An
Bord
Pleanála

**Inspector's Report
ABP-304346-19**

Strategic Housing Development

Former Chiver's site between Coolock Drive and Greencastle Road, Coolock, Dublin 17

00 Ground Floor Level

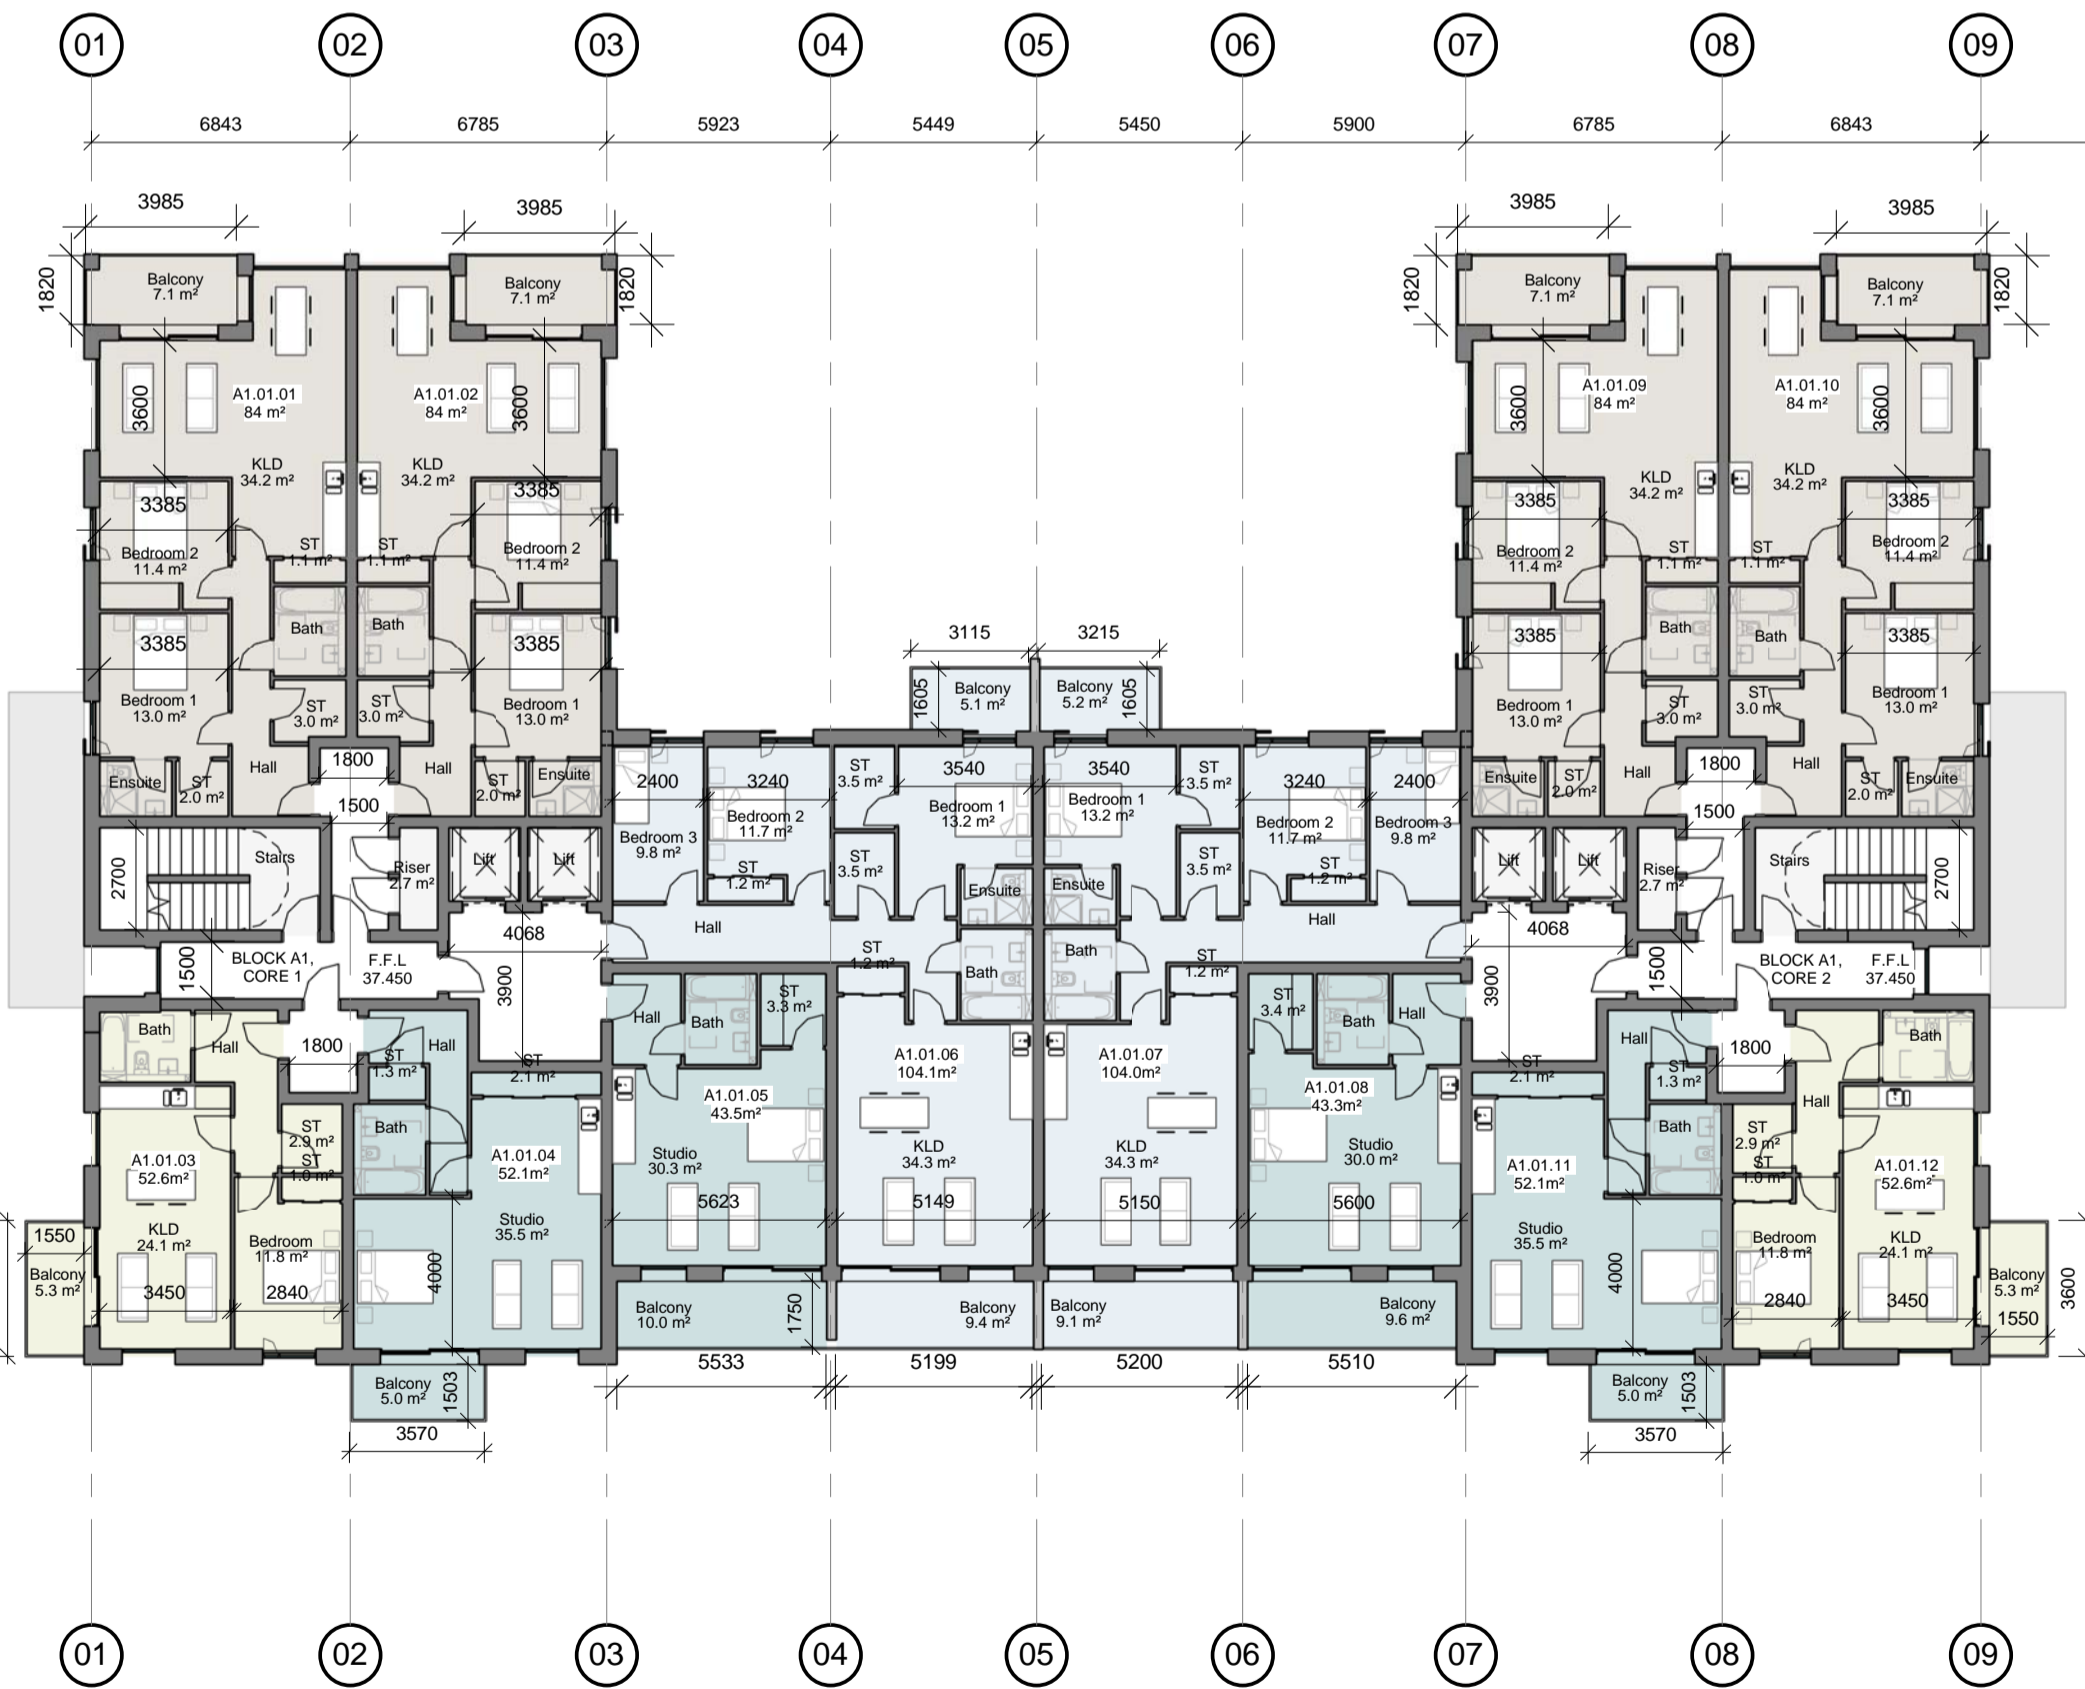
- The development varies in height from 6 storeys (19.175m) to 10 no. storeys (30.745m) for Blocks A1 and A2 and 3 no. storeys (10.4m) to 7 no. storeys (21.95m) for Block B and C.

- The ten storey landmark blocks onto the river park would be visible from distance and the site location would not warrant use of such height to identify the scheme at this location. This height would be more appropriate within and to draw focus to a district centre such as at the Cromcastle/Northside Shopping Centre.

- If ABP is inclined to permit the proposed development it is considered that the scheme would have least impact if it were to have a maximum height to blocks

A1 and A2 of six storeys while a maximum height of five storeys to the pop-up element of Block B onto Coolock Drive, being one storey higher than the rest of the street elevation of Block B while the remainder is five storeys rising to six at the above mentioned pop-ups.
